Please upload email to BE/71/18/PDH

From: [REDACTED]
Sent: 10 July 2018 12:29
To: Daun Johnson
Subject: RE: Prior approval for rear extension at 421 Chichester Road, Bersted

PROPOSED GROUND FLOOR
(Rear Extension)

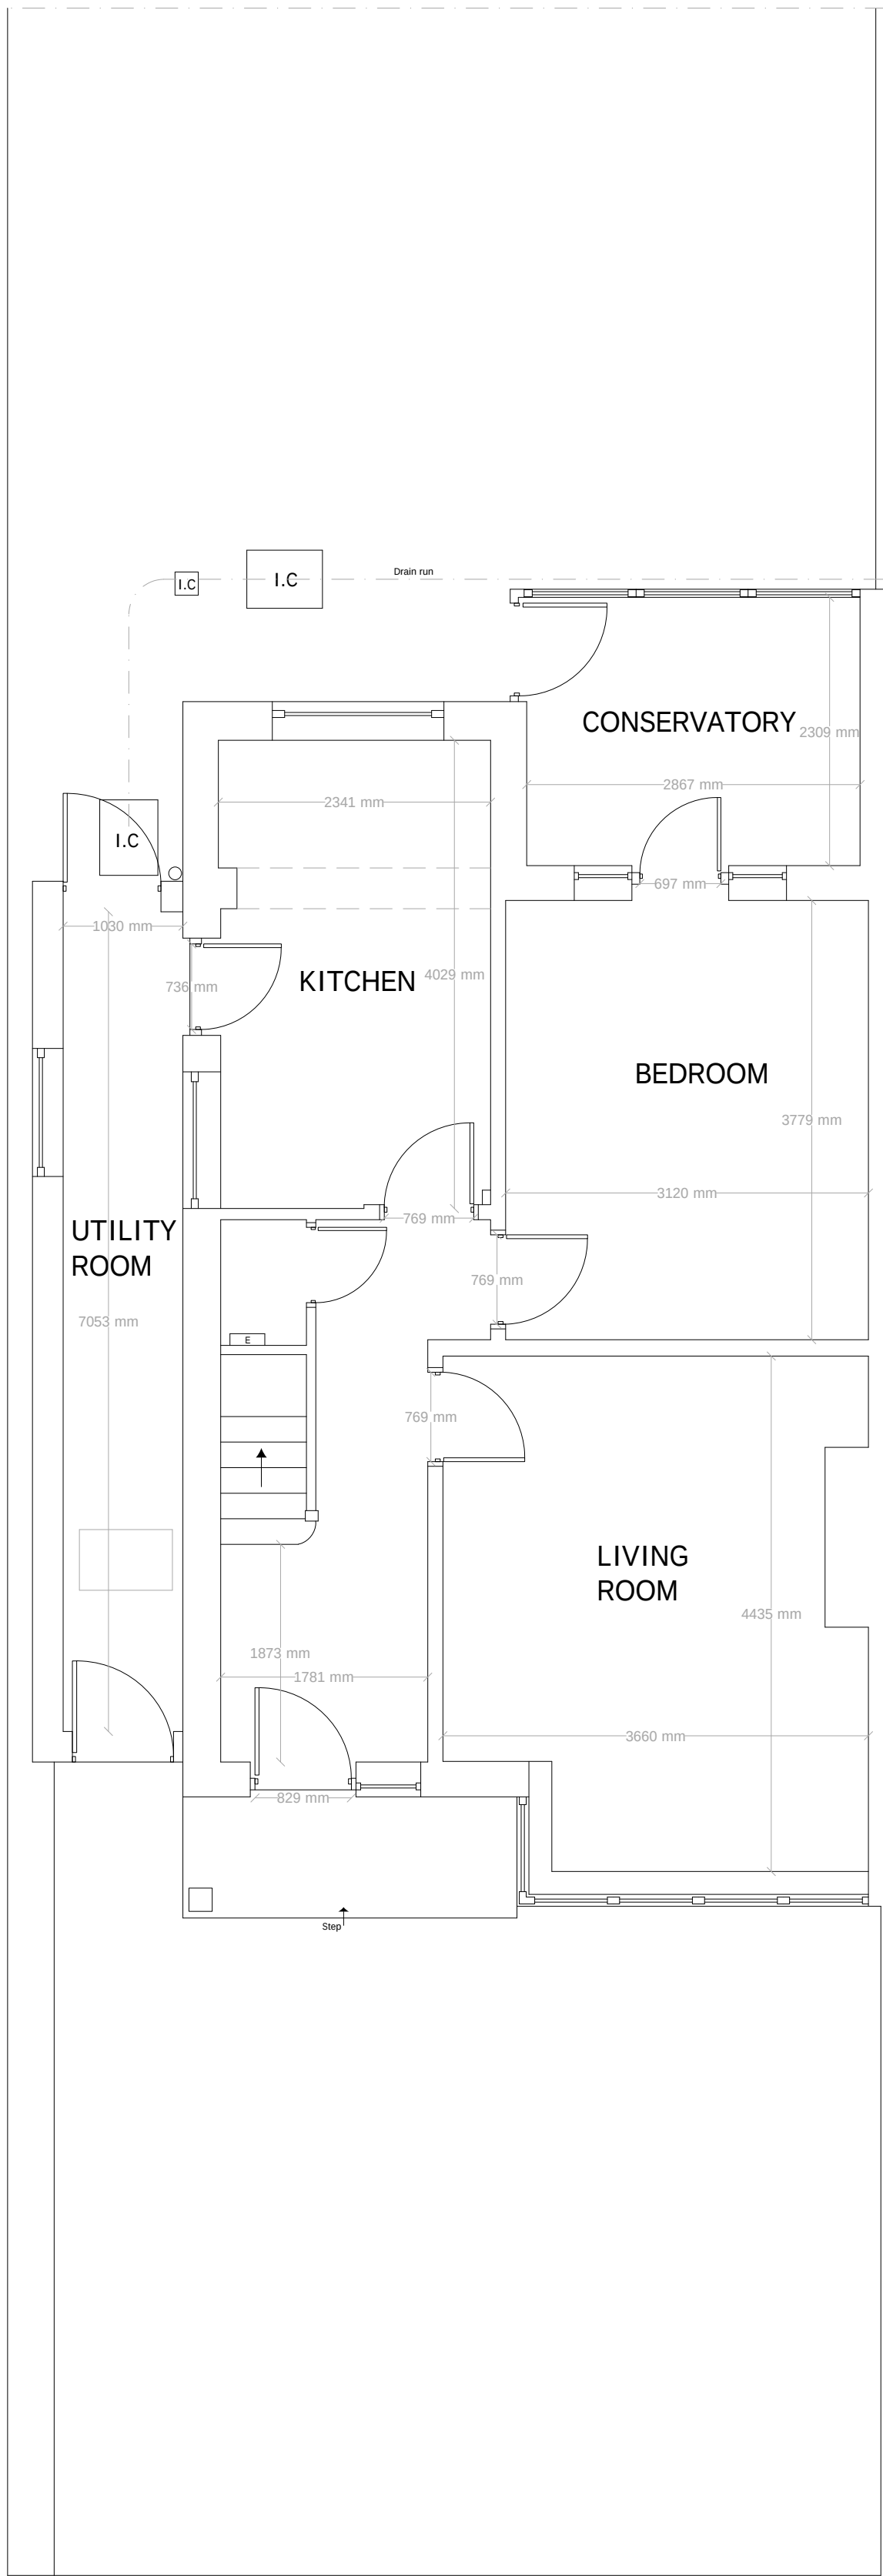
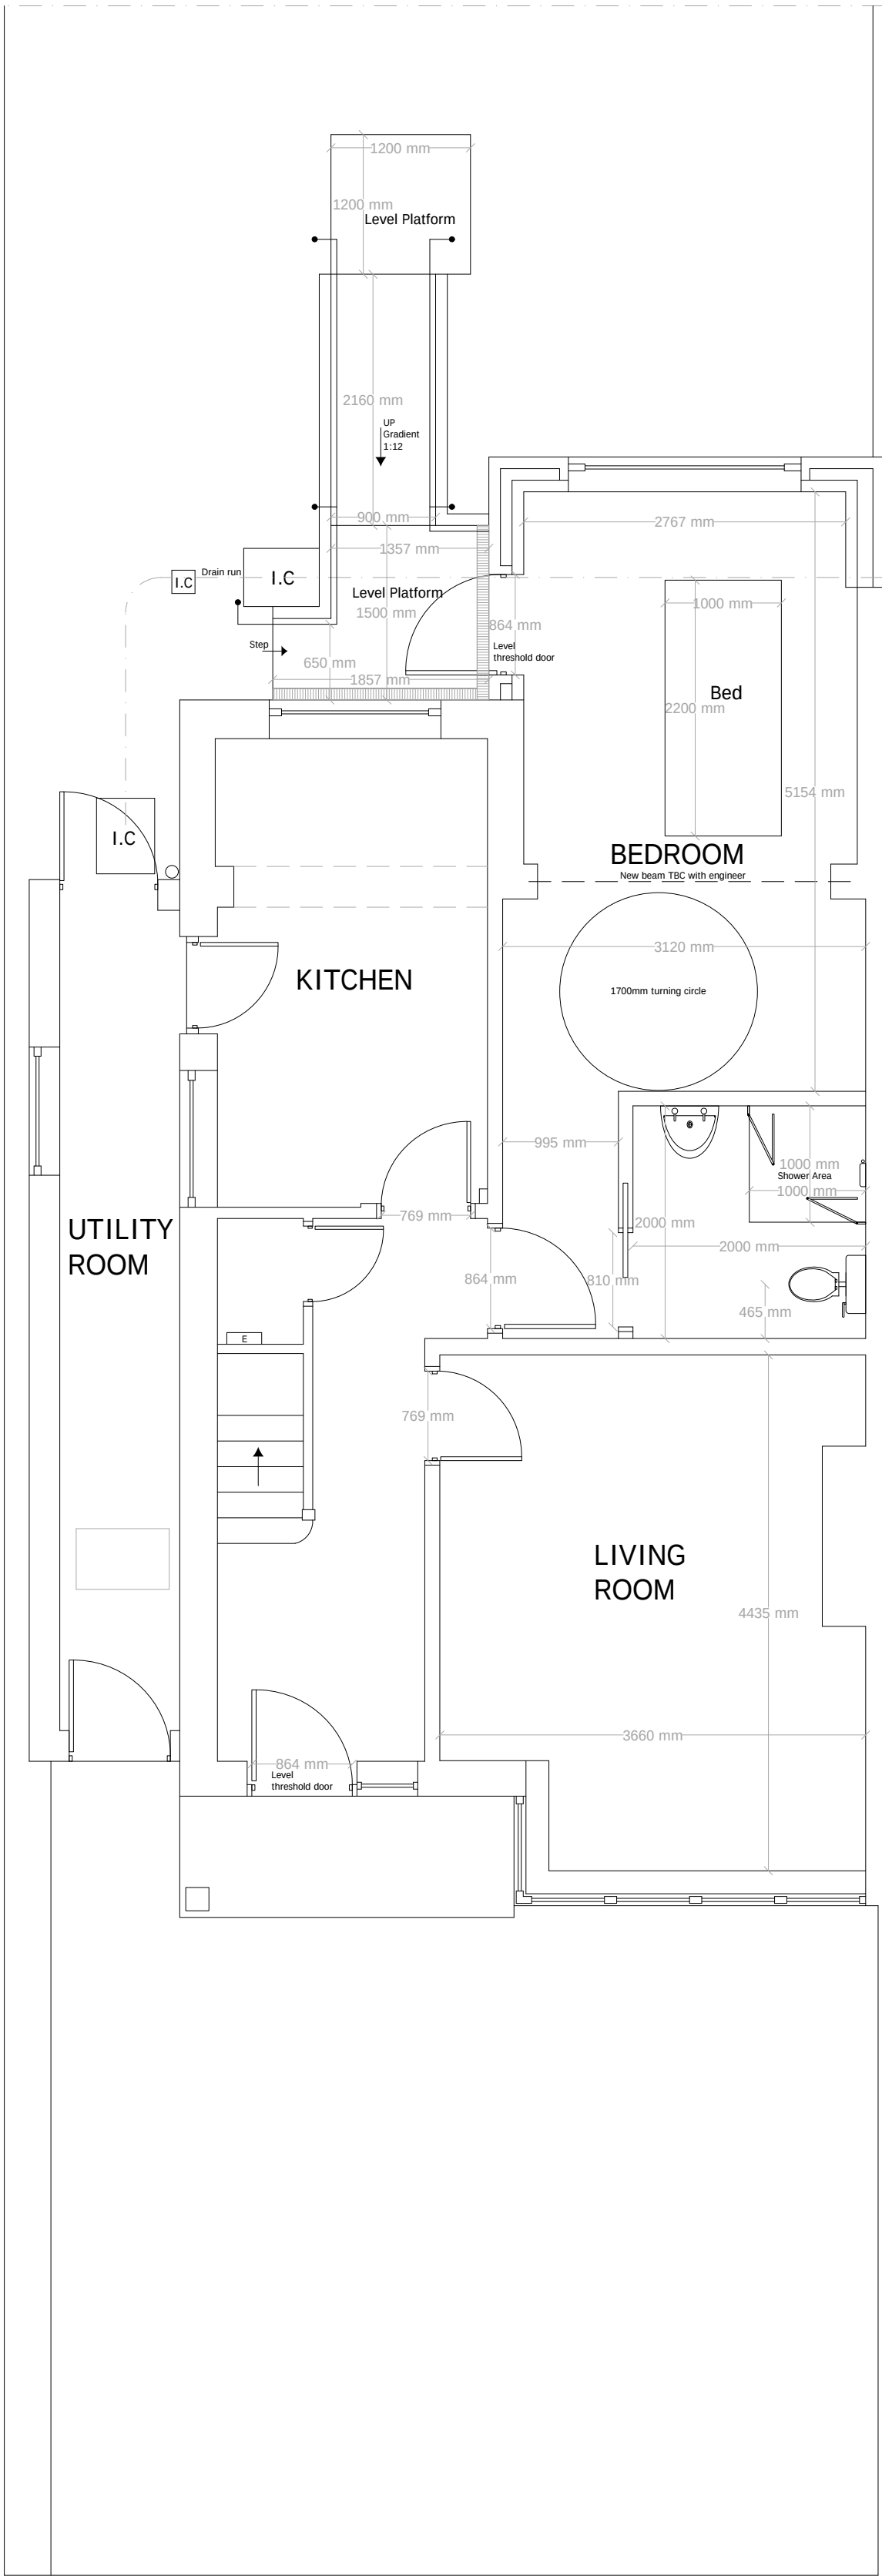
I am currently working on the above application and notice that on the proposed floor plan, level platforms and a gradient are shown.

Are these to be included within the description of the proposed works?

Also, please confirm the materials that will be used for the single storey rear extension.

The rear ramp shown on the drawings is not related to this application for the single storey rear extension.

The materials for the proposed extension will match with the existing property.
